From: Shaban, Sundas
Sent: 25 April 2022 15:19
To: _planningadvice
Subject: FW: H09-0186-22 - 19 North Parade

From: Shaban, Sundas
Sent: 25 April 2022 15:18
To: 'info@status-design.co.uk' <info@status-design.co.uk>
Cc: Fidler, Richard <rfidler@sholland.gov.uk>
Subject: H09-0186-22 - 19 North Parade

I can confirm condition 3 should read s follows:

PLAN AS PROPOSED

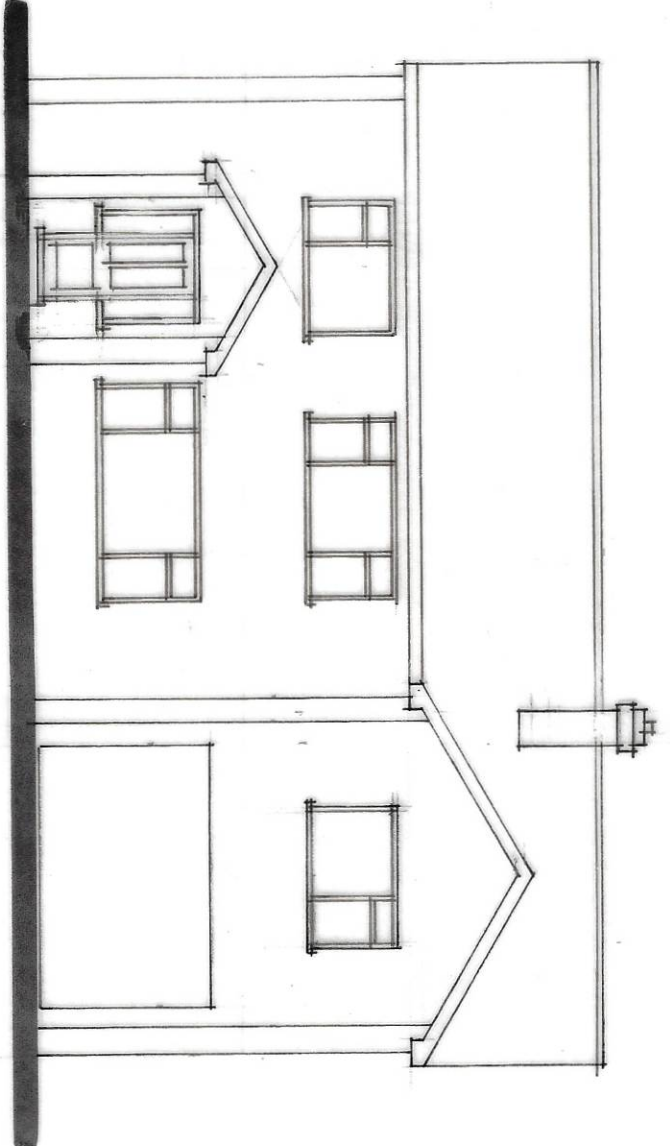
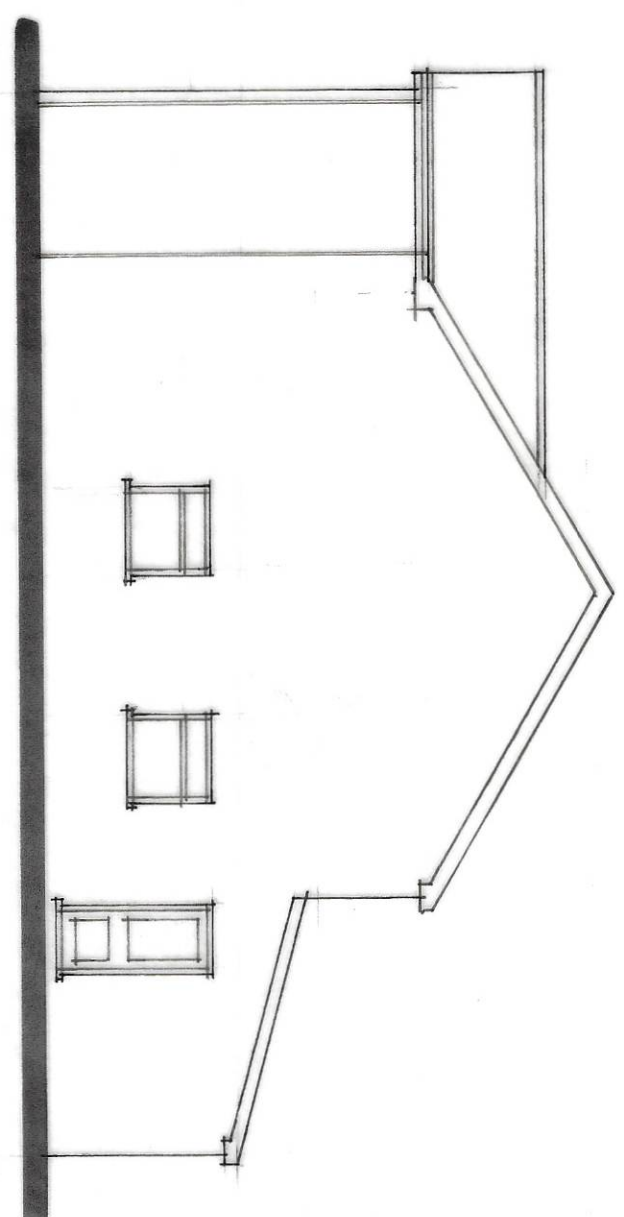
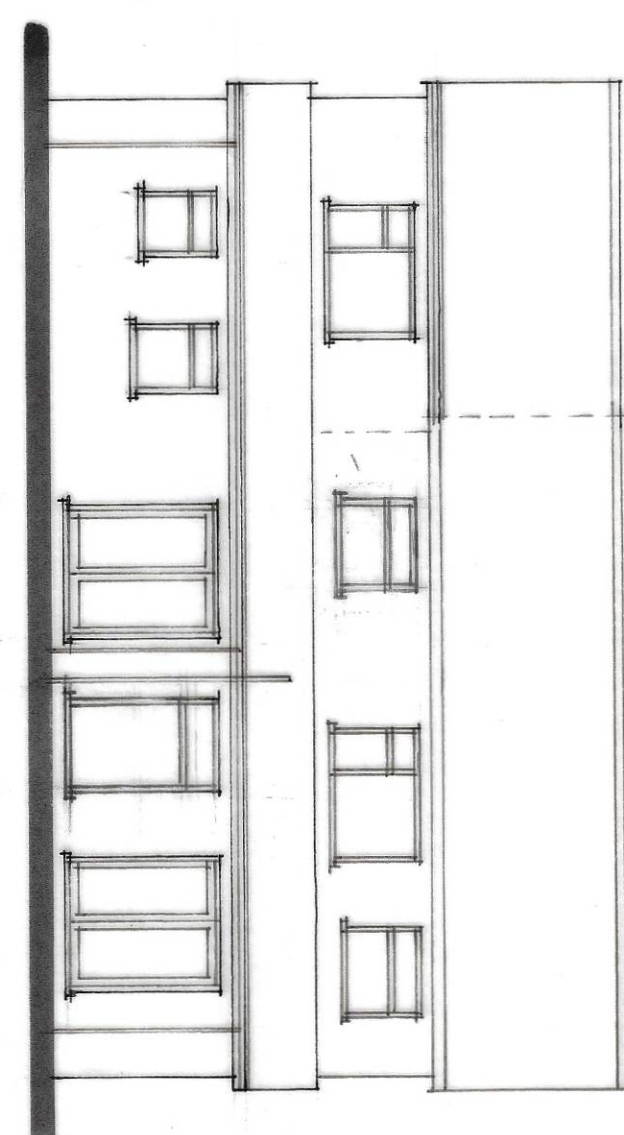
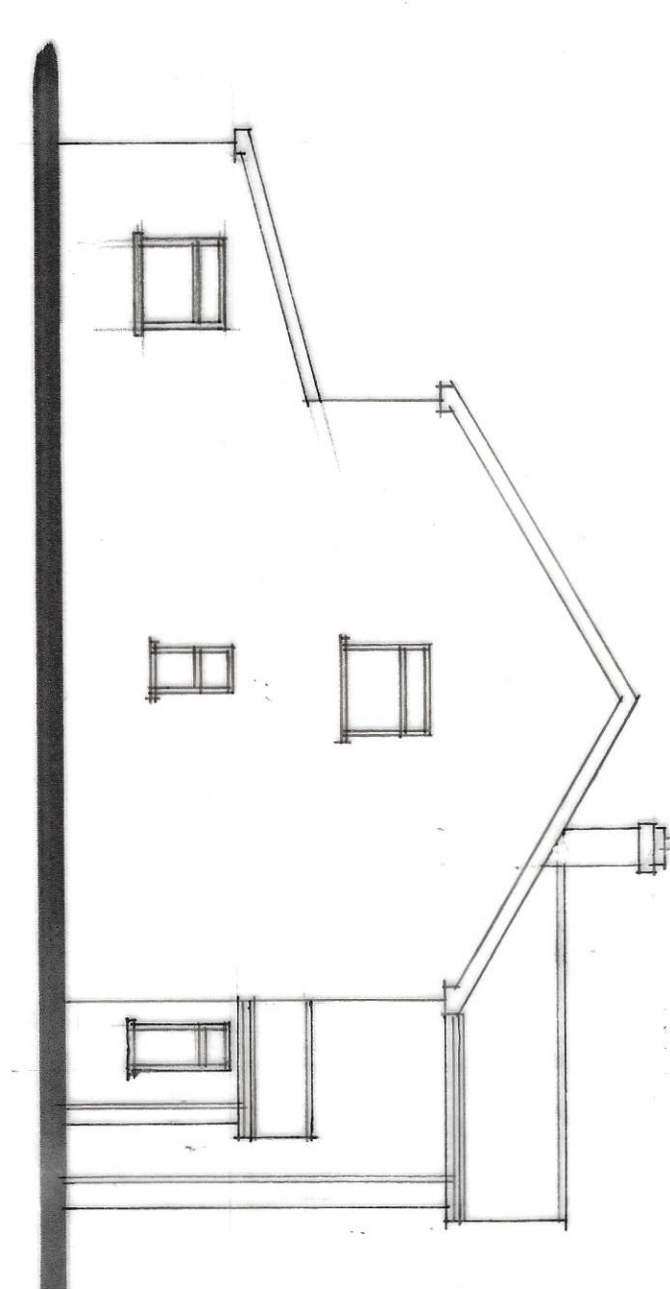
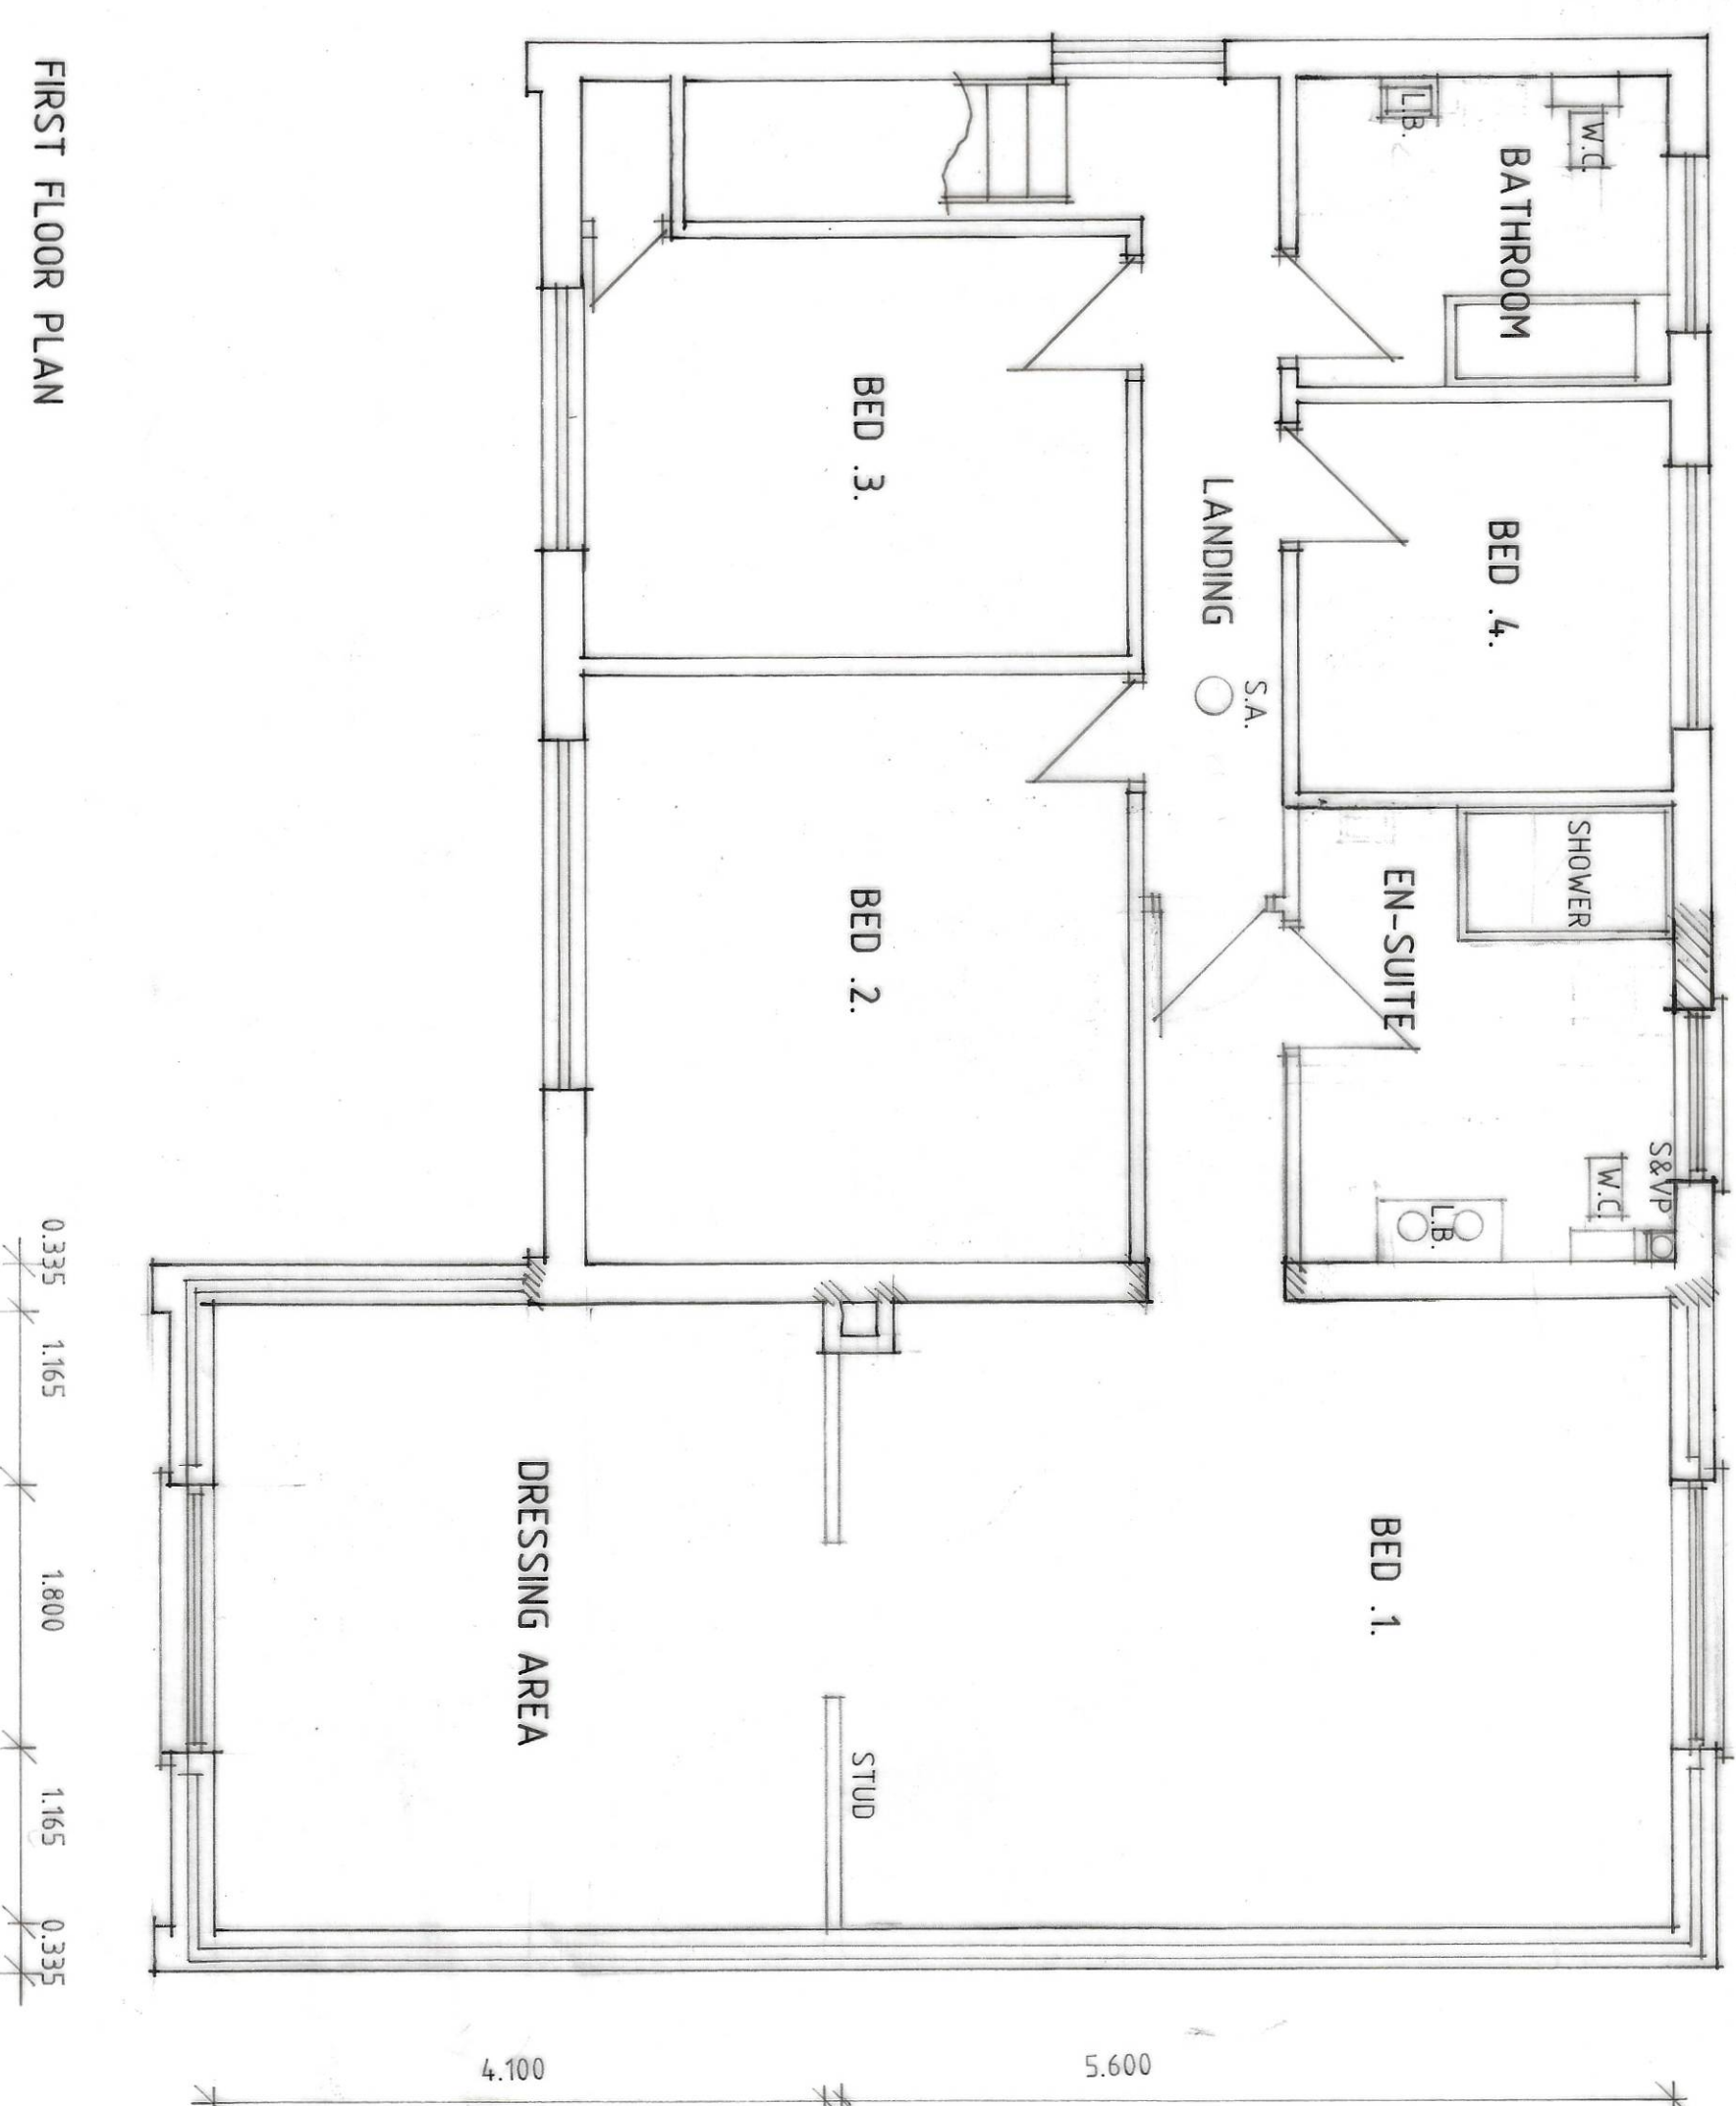
I understand there has been some misinterpretation with the submitted details of the above application and one of the conditions does not reflect what has been applied for.

Firstly I'd like to apologise for misreading the fact the entire property is proposed to be rendered.

'The external walls of the extensions and the existing dwelling shall be rendered and painted off white and all other external materials shall match as closely as possible those of the principal existing building on the site'.
